## **SUMMARY OF REGULATION 19 ISSUES FOR BROADWATER ROAD WELWYN GARDEN CITY- 3.11.2010**

It is considered that a Regulation 19 notice should request the following clarification / additional information:-

03. EAST ELEVATION

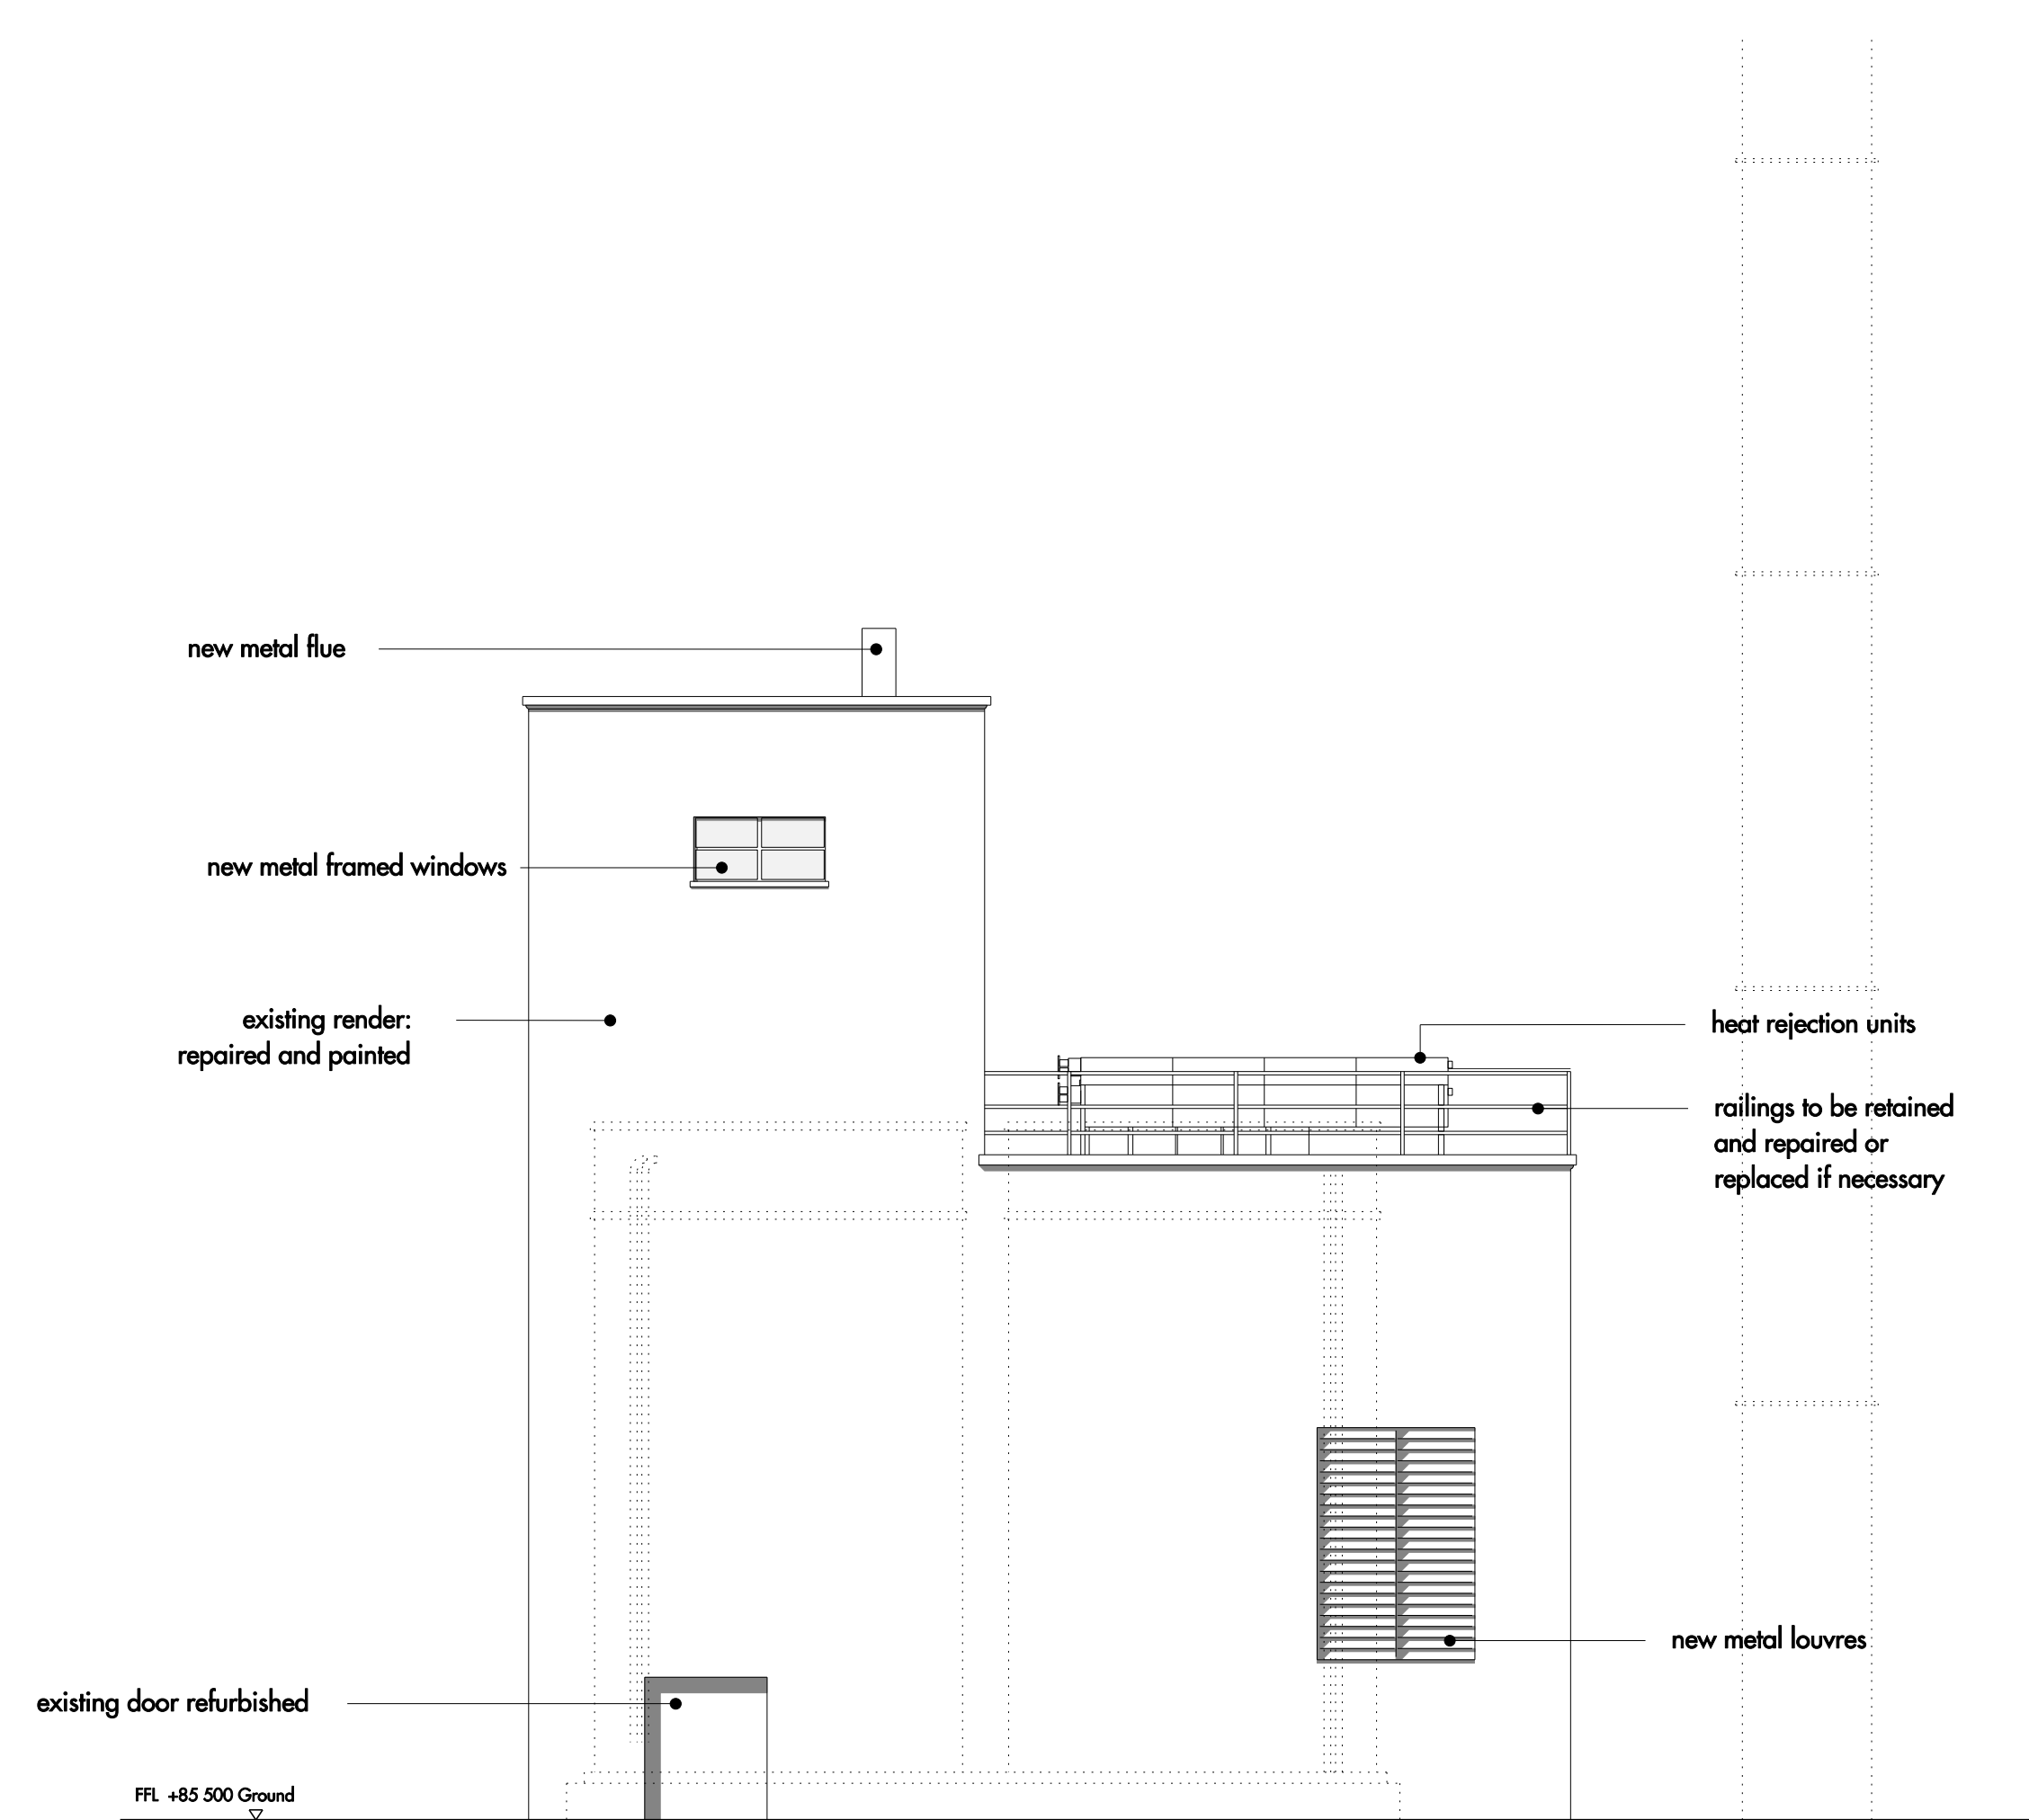
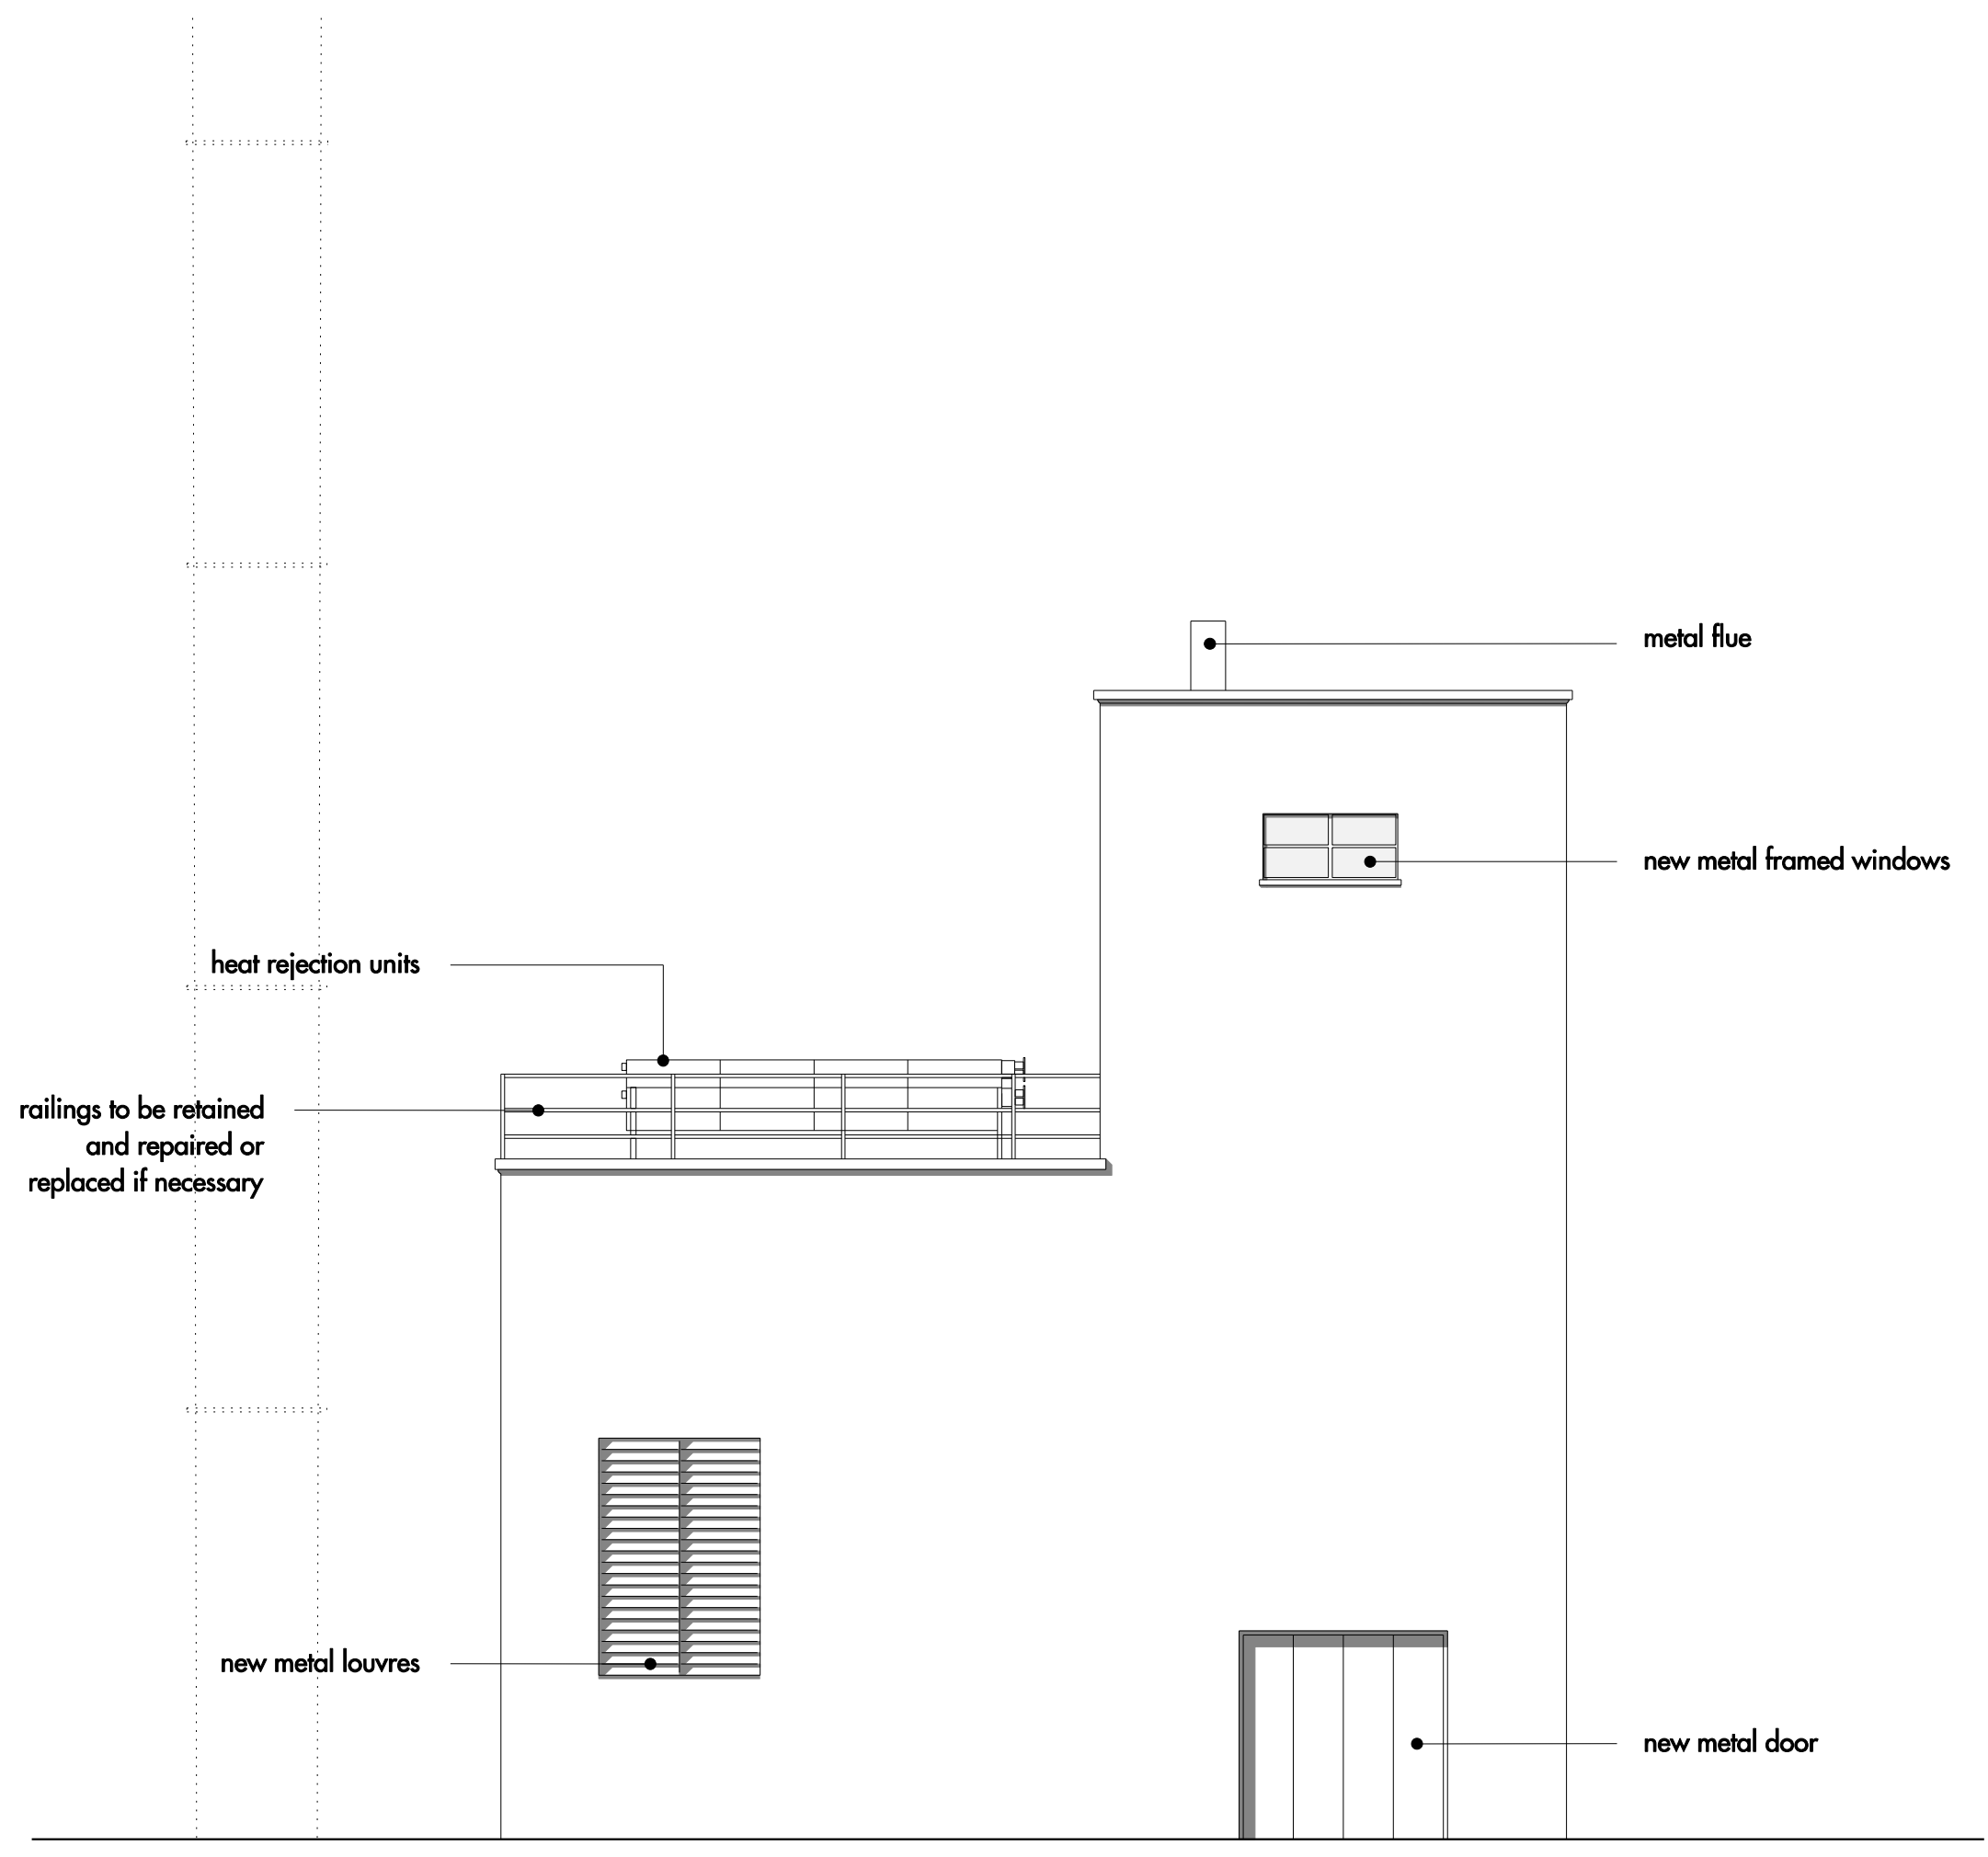
Confirmation is needed on the fuel type proposed for the CHP, and whether or not the CHP will serve the whole development. Confirmation is also needed as to whether the existing building and stack proposed to be re-used for this purpose will be adequate to house all of the plant required. Confirmation should be provided of the air quality, noise and visual impacts that will result from the CHP, as nearby residential units and other uses which may be adversely affected by the CHP lie within the area of the detailed application.
